2019 Financial Assurance Estimate Form  
(with pre-plat construction)

PROJECT INFORMATION			
The Trails at Aspen Ridge Filing No. 2	11/6/2019	\$ 389,310.00	PUDSP-191
Project Name	Date		PCD File No.

TRAILS AT ASPEN RIDGE			
FILING NO. 2			
FINAL GRADING & EROSION CONTROL PLANS			
LEGEND & ABBREVIATION NOTES			
DESIGNED BY: NMS	SCALE	DATE ISSUED: NOVEMBER 2019	DRAWING No.
DRAWN BY: CRD	HORIZ. N/A	3 OF 8	GEN01
CHECKED BY: NMS	VERT. N/A

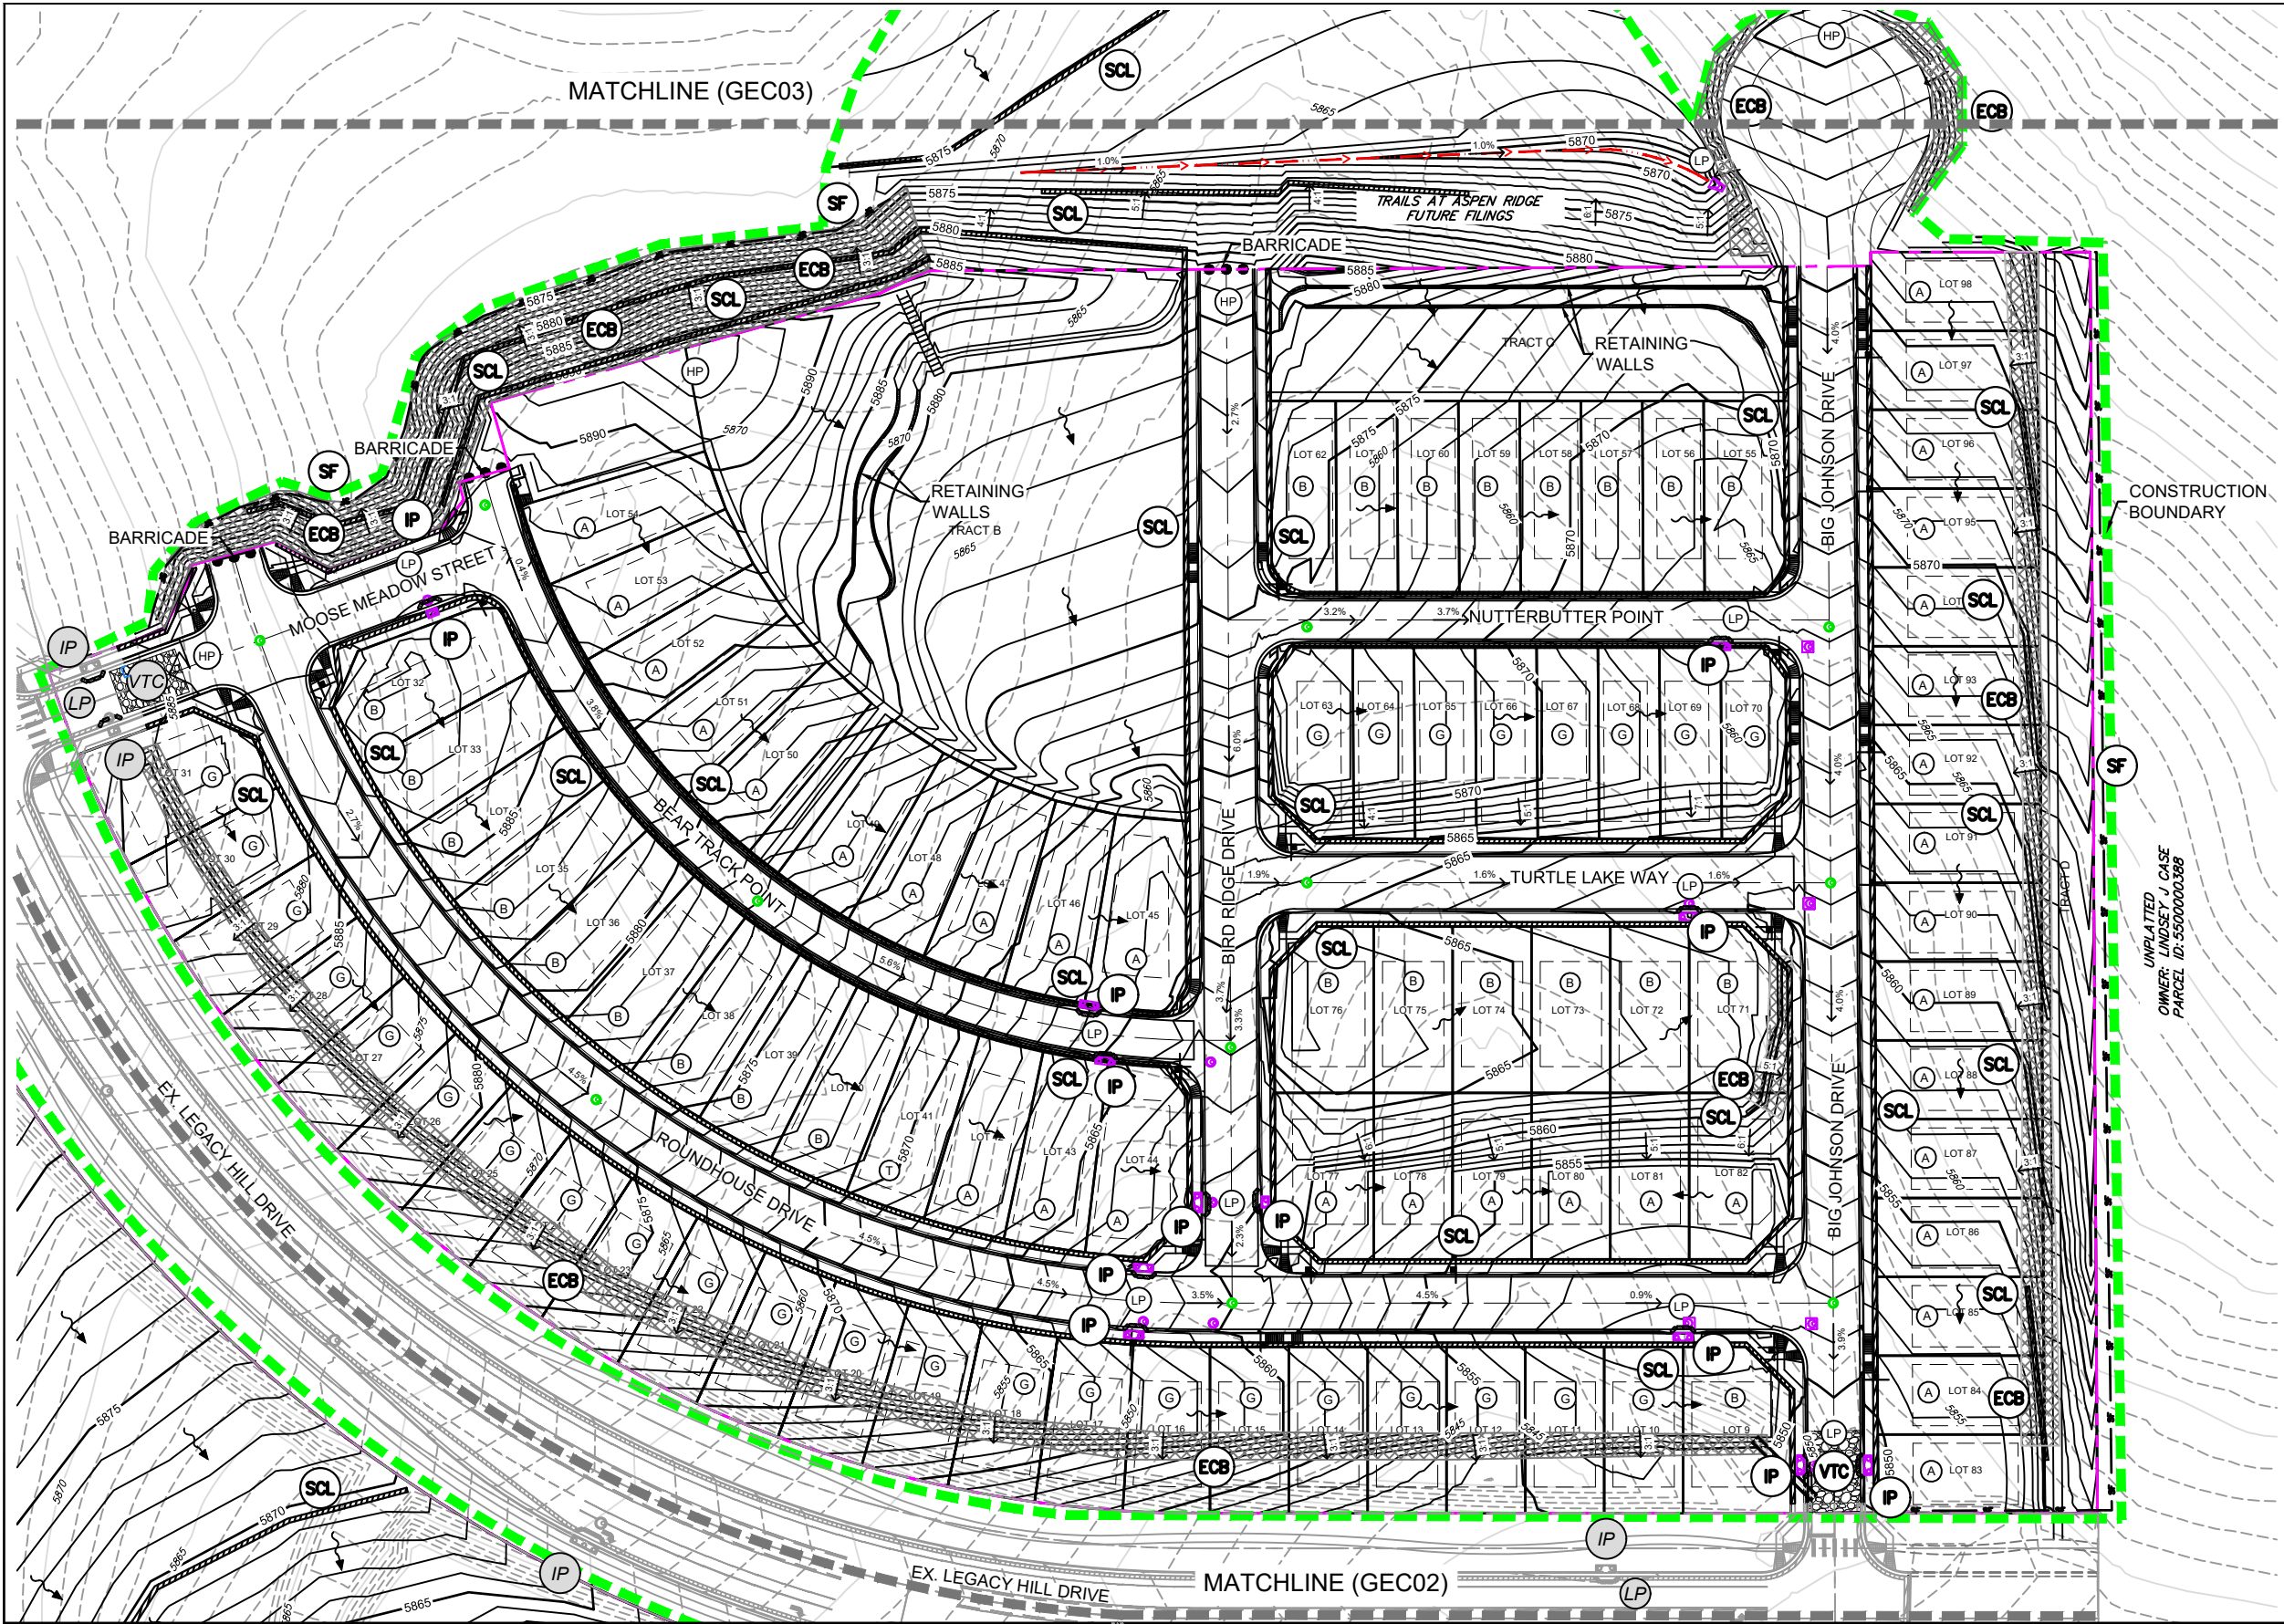
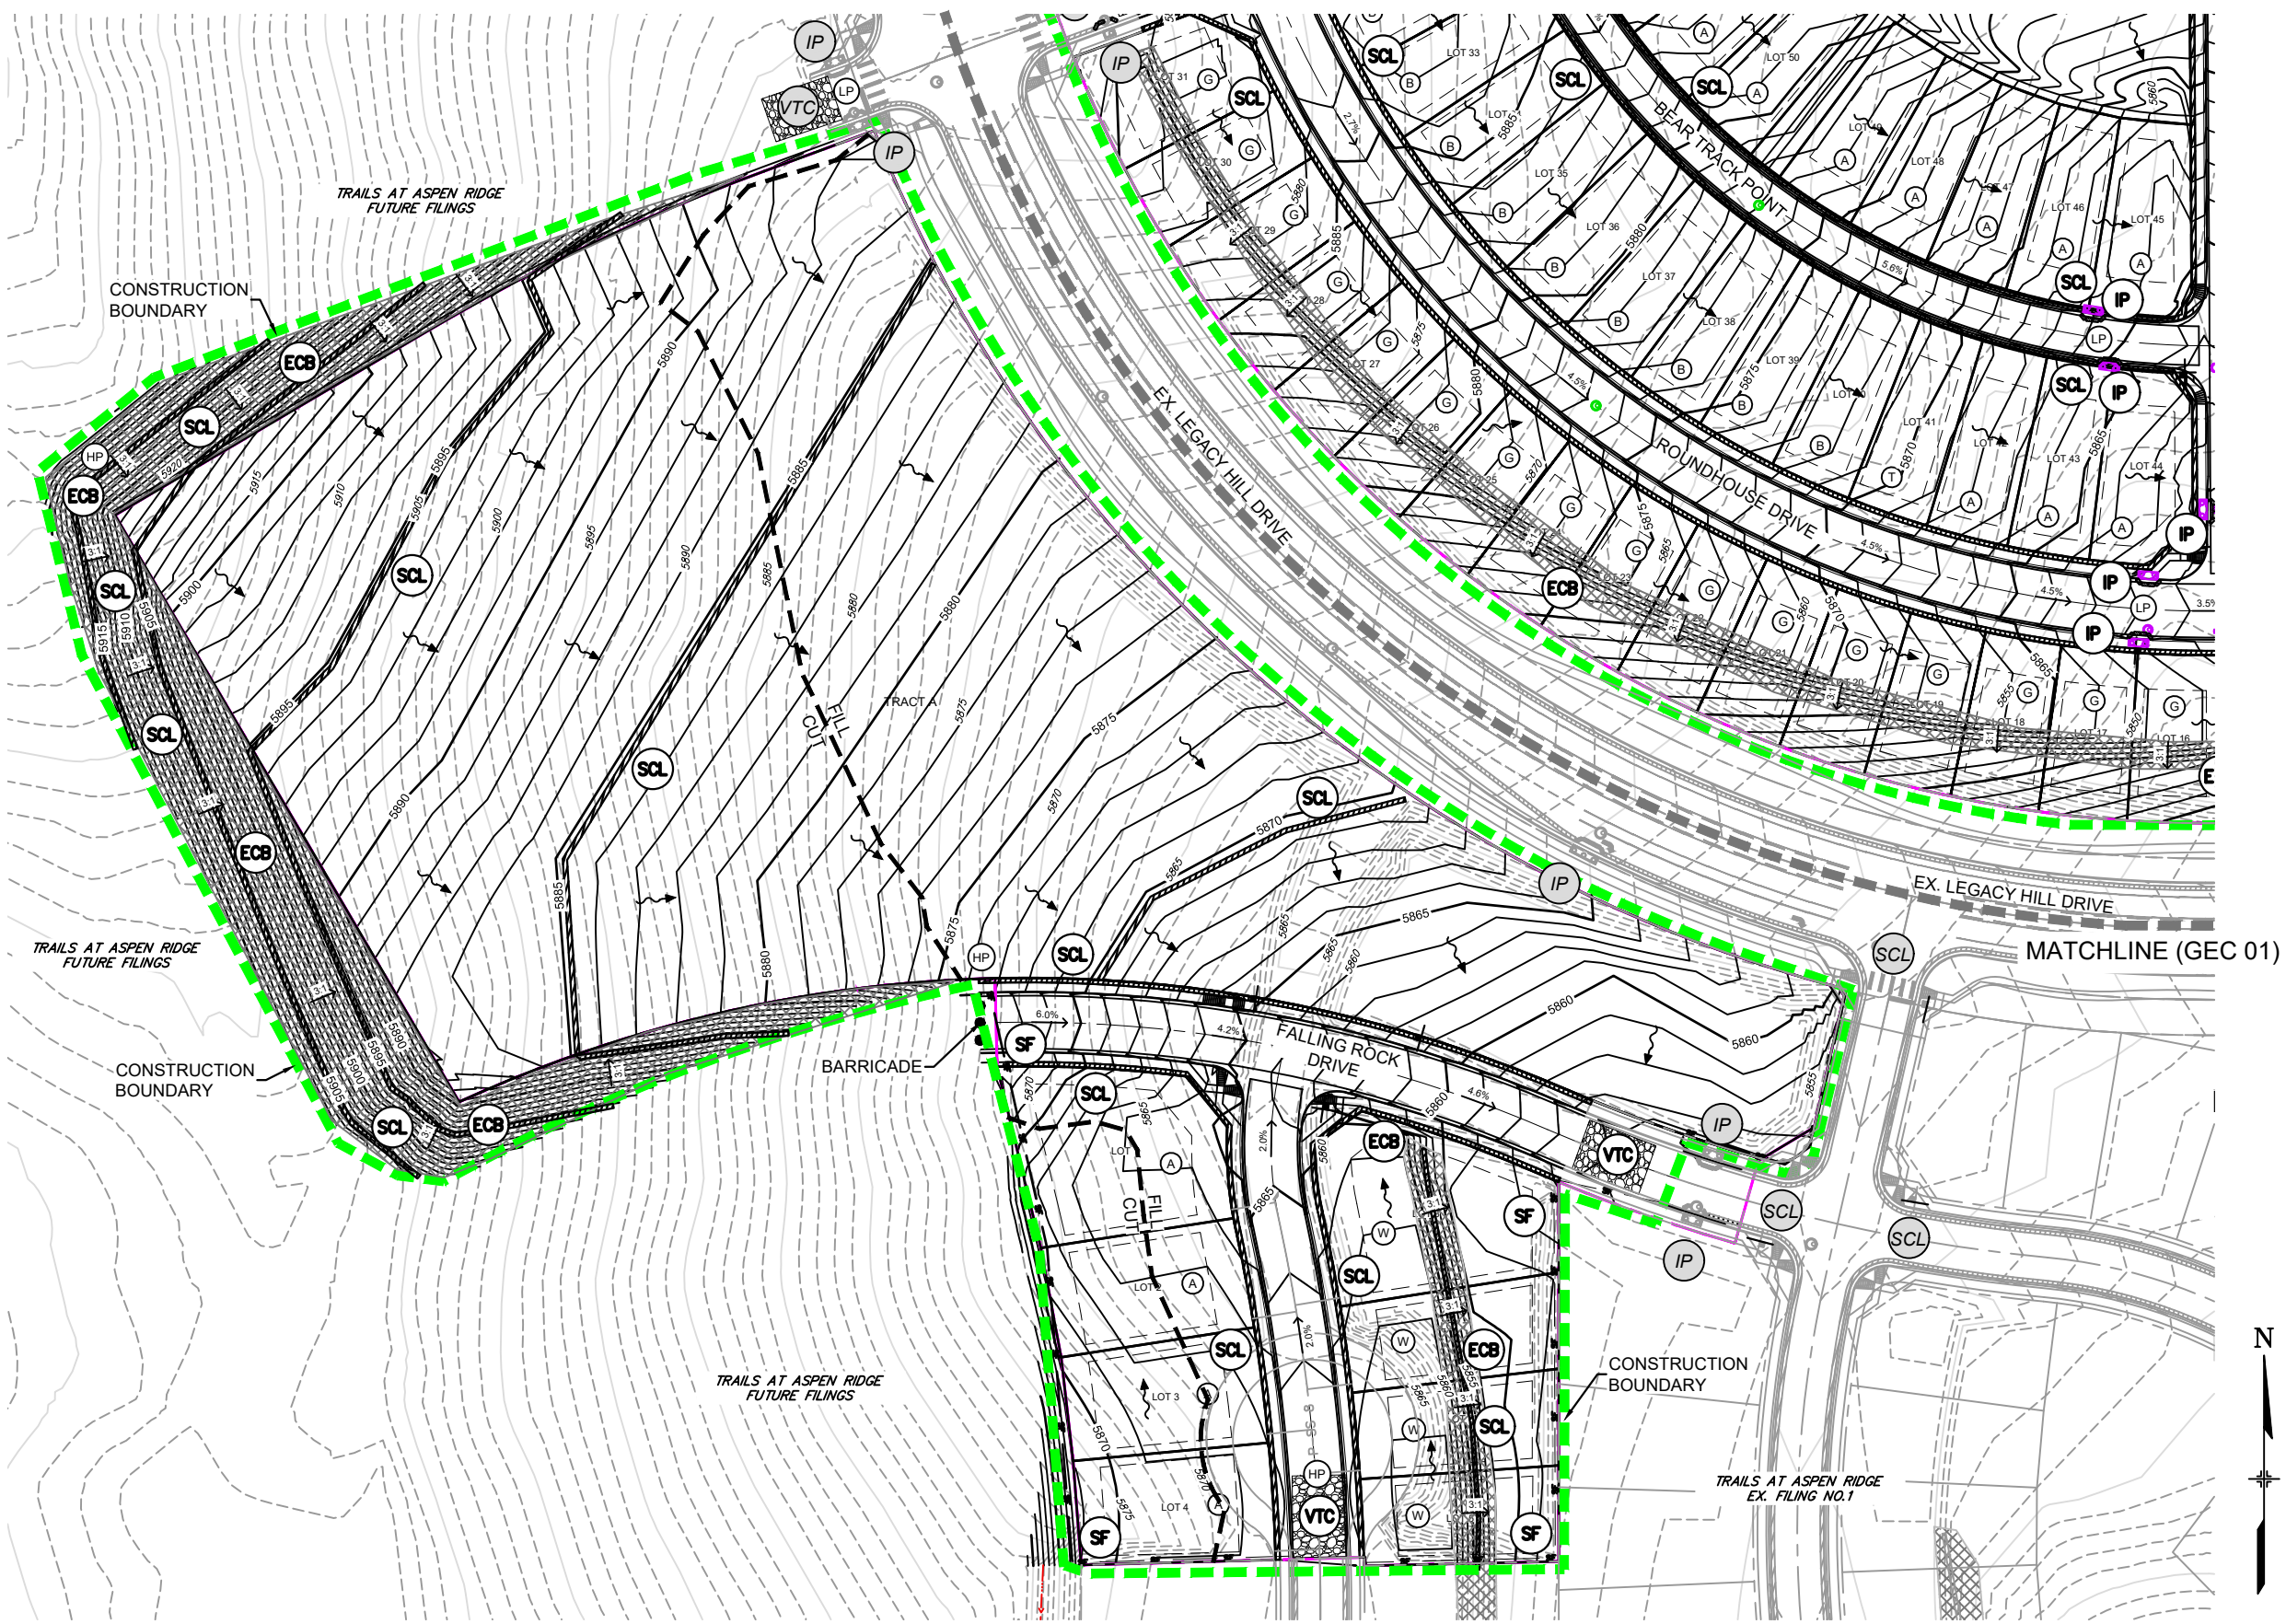
update the items and quantities accordingly per comments on the GEC plan.

There are 13 inlet protections shown on the GEC plan. Please revise.
